ASSESSMENT REPORT

Section 75W Modification

Fern Bay Seaside Village, Fern Bay, Port Stephens Local Government Area MP 06_0250 MOD 6

**ATTACHMENT 1**  
**– PLAN SHOWING LOCATION OF PATHWAY ON NELSON BAY**  
**ROAD**

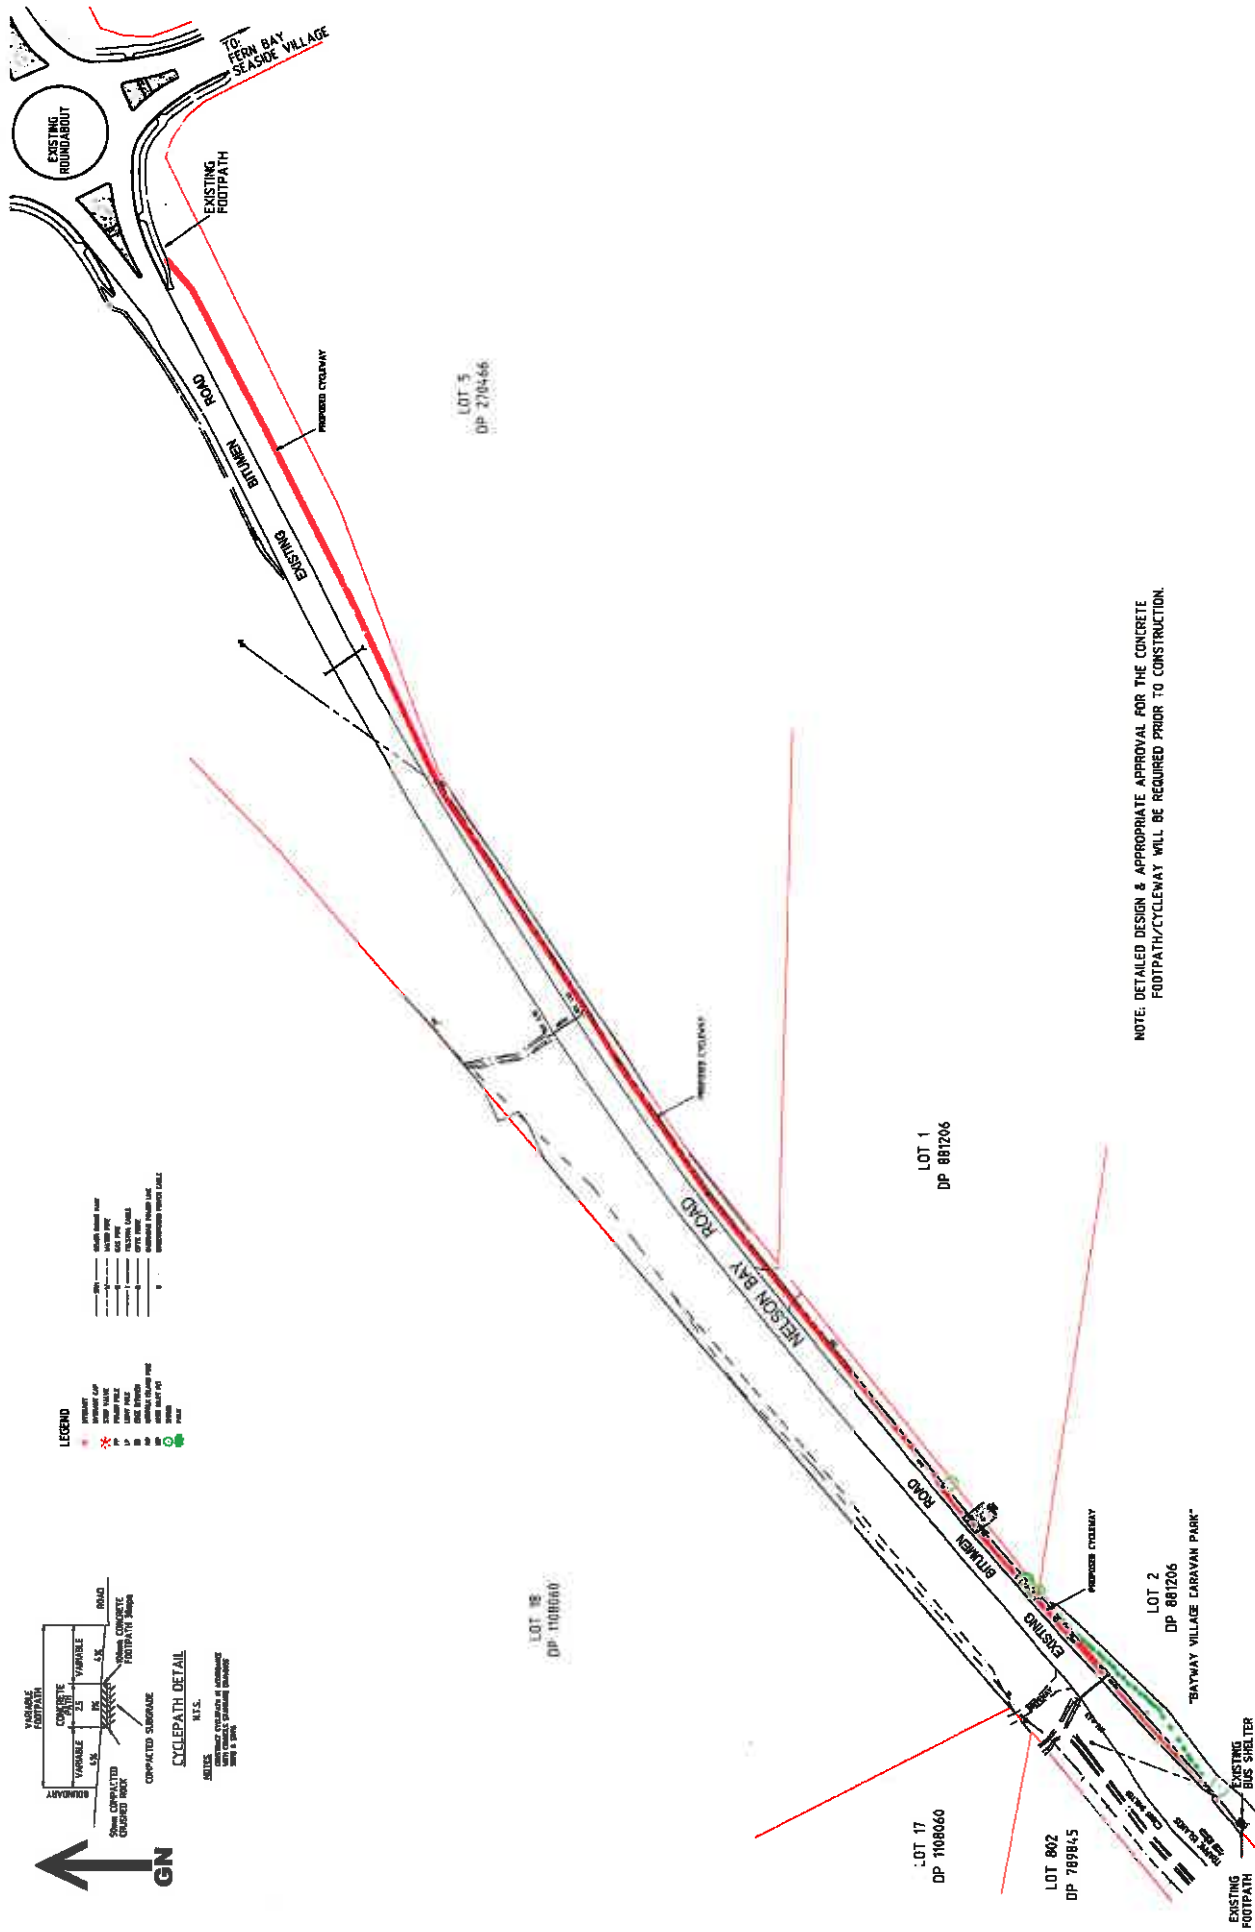
The Department has reviewed the Proponents justification and the comments provided by the Council and the RMS and agrees that it is not be possible for the Proponent to construct the section of the footpath/cycleway between Lot 1 in DP 881206 and the bus shelter at the entrance of the Bayway Village on the basis that the Proponent does not own this land (see **Figure 3**). In addition, the Department notes that to date neither the Council or the Proponent have been unable to acquire sufficient land to enable the construction of the portion of the footpath/cycleway south-east of Lot 1 in DP 881206.

Given the above, the Department considers that the proposed modifications to Condition B4 will ensure that the footpath/cycleway is constructed to the maximum possible extent within the project area. In addition, the Department supports deferring the timing for the construction of the footpath/cycleway to ensure that the Proponent has sufficient time to consult with the Council and the RMS on the final design of the path.

Furthermore, the Department has concluded that in order to ensure cyclists can access the bus shelter at the Bayway Village the Proponent will need to construct a road shoulder treatment in the area between the end of the pathway and the bus shelter adjacent to the entrance of the Bayway Village.

The Department has recommended modifications to Condition B4 to reflect the above.
